Application H17-0622-20
Location Land adjacent 23 Stockhouse Lane Surfleet Spalding PE11 4AR
Proposal New detached dwelling with attached garage

PLANNING APPLICATION REFERENCE NO. H17 - 0622 - 20
Land Adjacent to 23 Stockhouse Lane, Surfleet

Project:	New Dwelling	Date:	July 2020
Address:	Stockhouse Lane, Surfleet, Spalding	Scale:	1:200 on A3
Client:	Mrs T Brand	Job No:	20073
Drawing Title:	Proposed Site Plan	Dwg No:	02 A

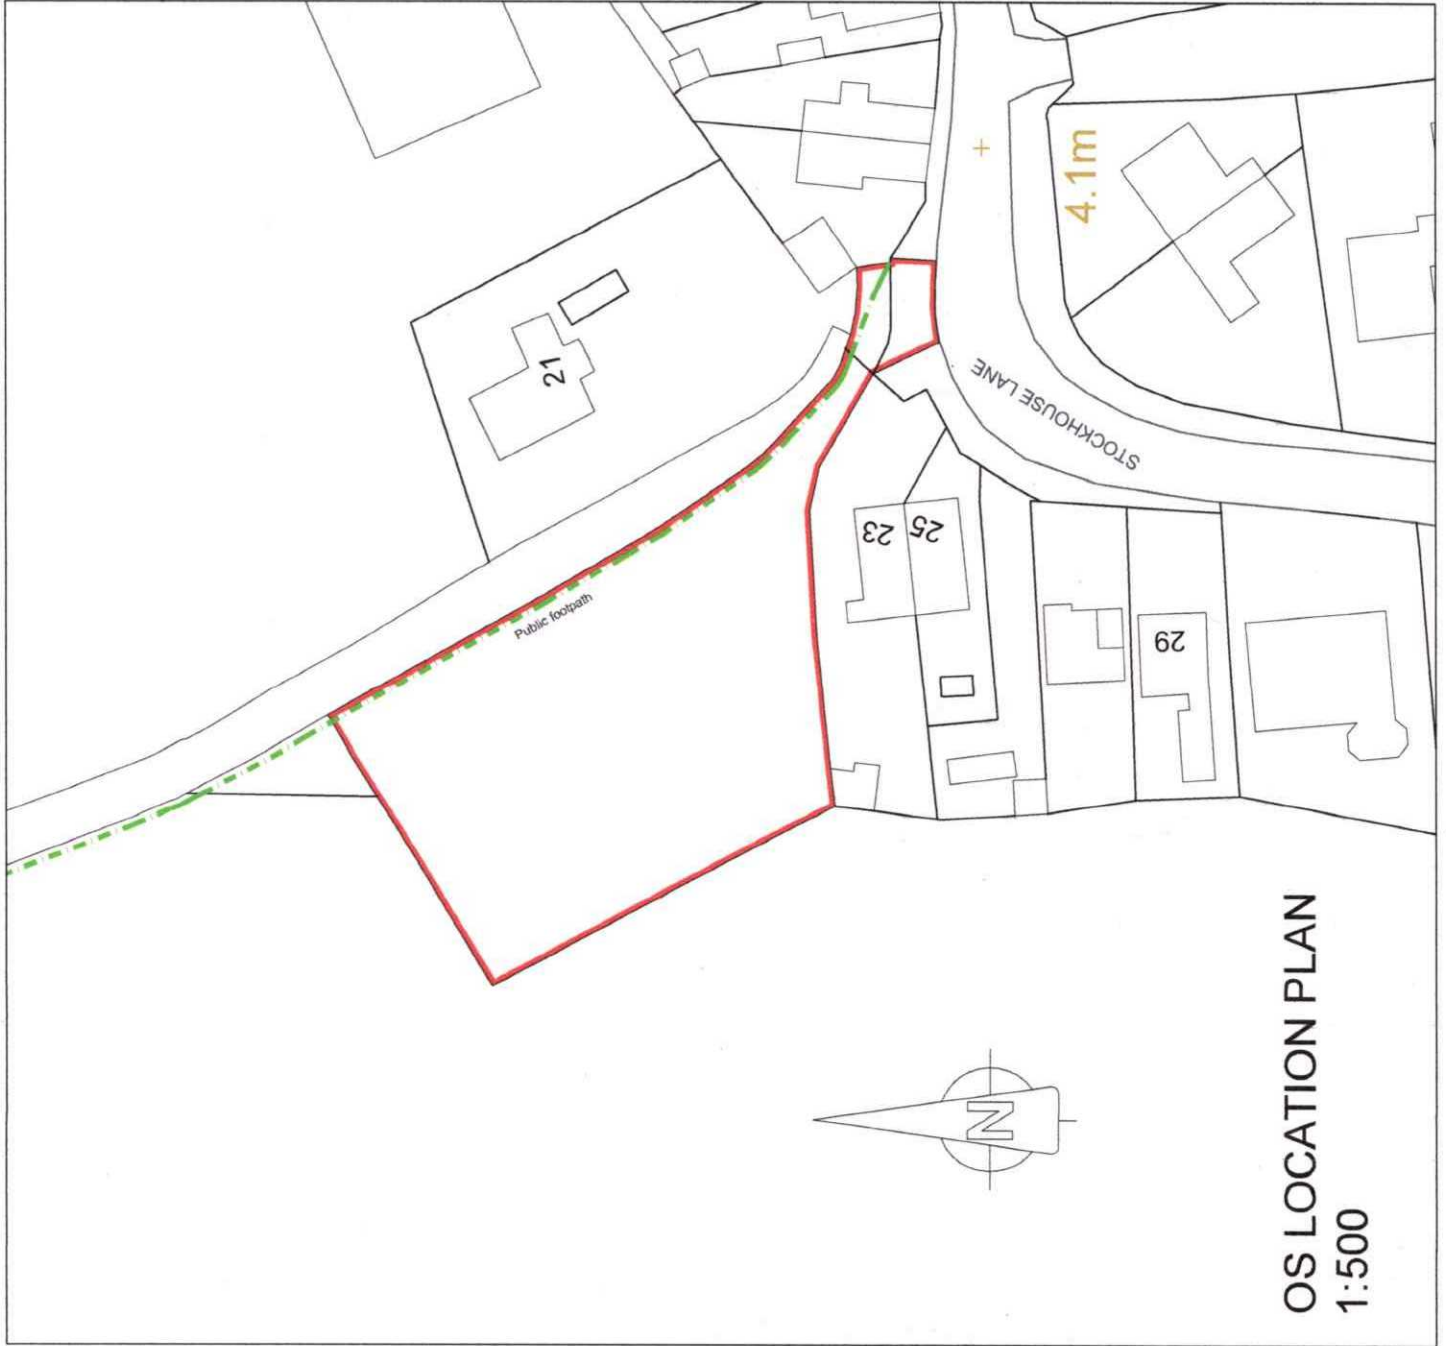
Thank you for your letter of 7th August 2020 regarding the above planning application. Surfleet Public Footpath No. 5 is affected by the proposed development.

- i/ It is expected that there will be no encroachment, either permanent or temporary, onto the right of way as a result of the proposal.
- ii/ The proposed development should not pose any dangers or inconvenience to the public using the right of way.
- iii/ A minimum width of 2m should be retained to accommodate the public footpath.
- iv/ The surface of the public footpath should not be disturbed without the prior consent of the County Council.
- v/ Further discussion is required regarding the surfacing of the section of public footpath which runs along the proposed drive. Pea gravel is considered to be an unsuitable surfacing material.
- v/ No gates should be erected across the public footpath or gate posts erected at either side of the public footpath.
